Date: 14 December 2021
Our ref: 376288
Your ref: ExQ1

Able Marine Energy Park Material Change 2: Examiner's written questions ExQ1

AMEP Material Change 2 written questions ExQ1

Project: **ABLE Marine Energy Park**  
Client: **ABLE UK Limited**  
Drawing Title: **Quay General Arrangement Changes**

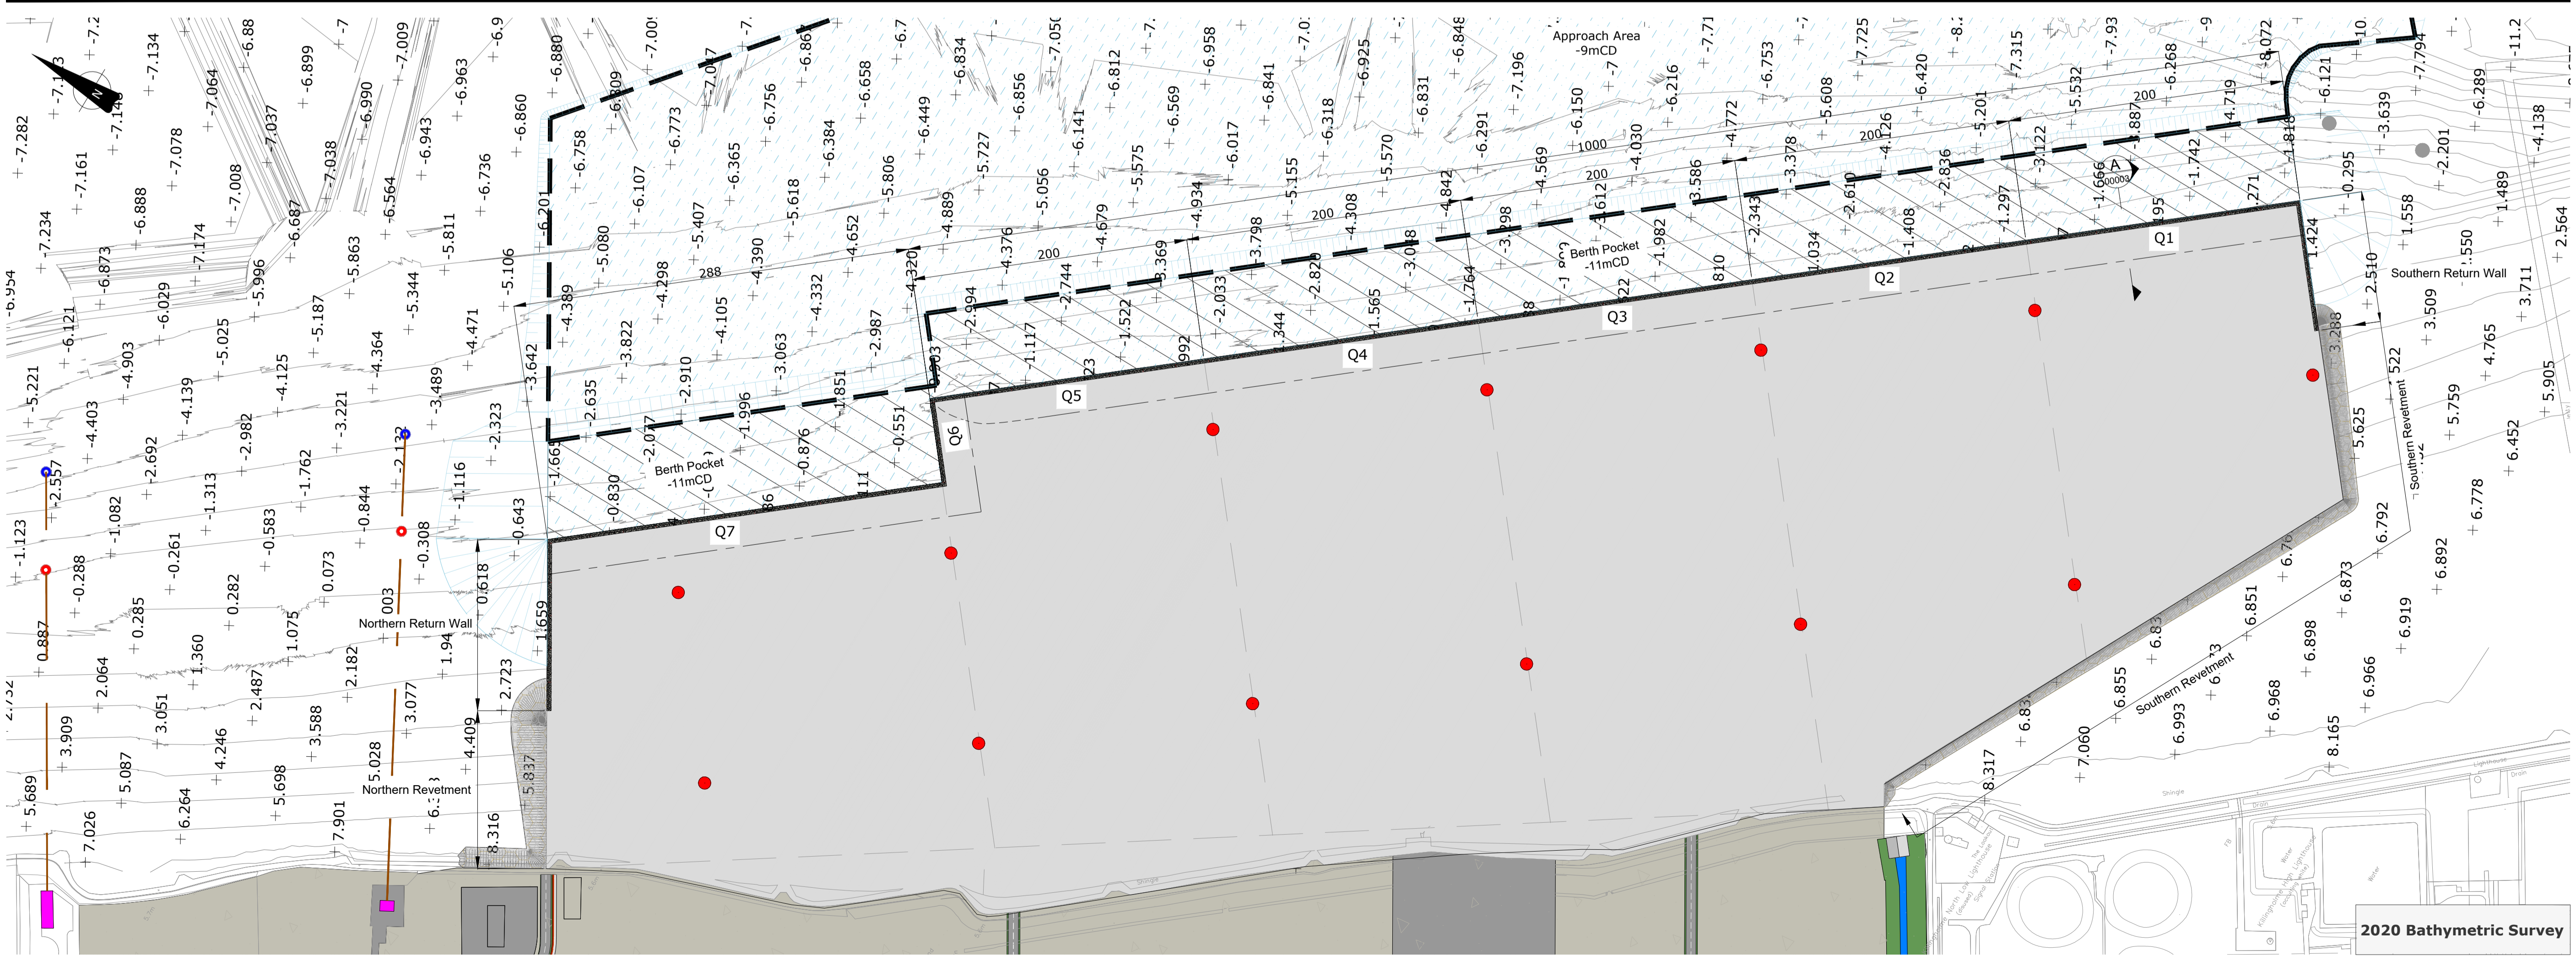
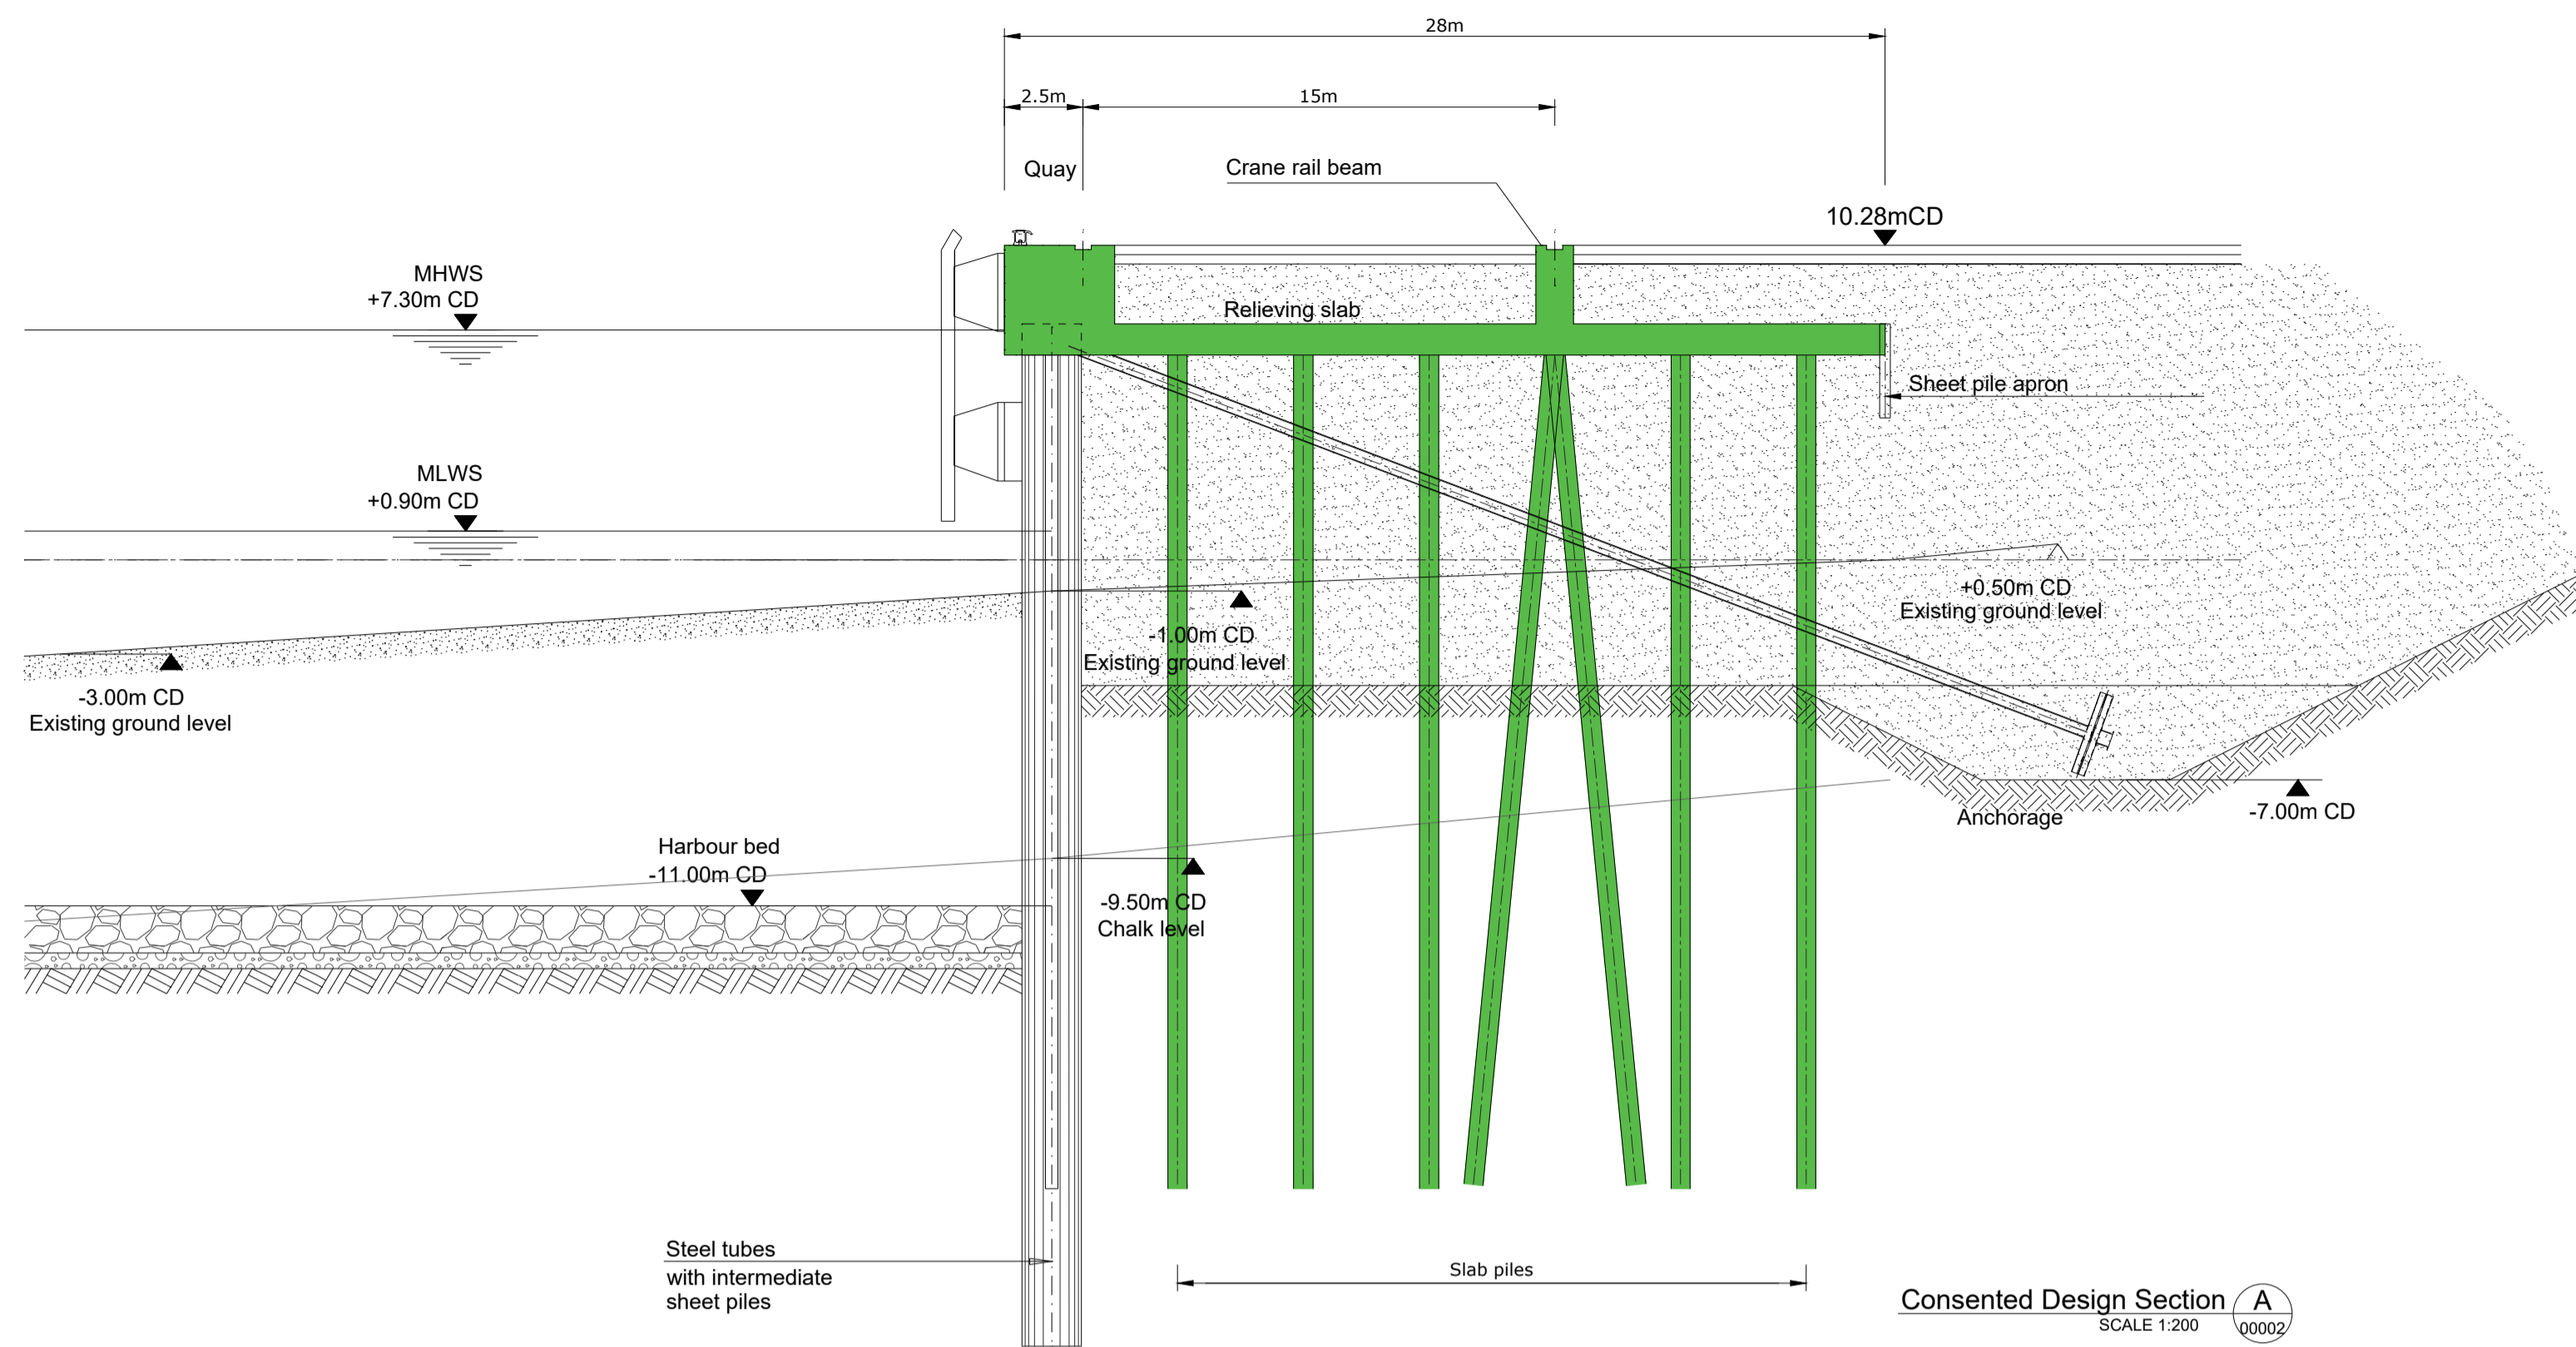
| 3.3.3 | <p>Further assessment is required on the potential change in operational effects due to changes to the design of the quay. This change could increase noise disturbance levels at North Killingholme Haven Pits (NKHP), particularly from vessel traffic and port activity. This information should be provided in the HRA in addition to the Updated Environmental Statement.</p> | <p>The HRA Part 2 paras 8.11 states that "<i>the quay redesign will not change the operational phase effects of the Development</i>" and para 8.12 states "<i>There would be no change in the extent of the operational noise disturbance resulting from the proposed material change.</i>" However, there is no justification or evidence provided for how this conclusion has been reached and we advise that this should be clarified in the sHRA.</p> <p>Section 8.12 states: "<i>There would be some change to the planned lighting regime in order to accommodate the new quay alignment, but lighting levels are subject to approval under Schedule 11 of the extant DCO, Requirement 24 and require consultation with Natural England before being approved by the local planning authority.</i>" We advise that further clarification is also required as to the potential impacts from lighting as a result of the changes to the quay design.</p> |

| 5.1 | Further explanation within the appropriate assessment to demonstrate operational effects of alteration to the design of the quay and the effects of increased vessel movements on intertidal SAC habitats and disturbance to SPA/Ramsar features. | See 3.3.2 and 3.3.3 above. |
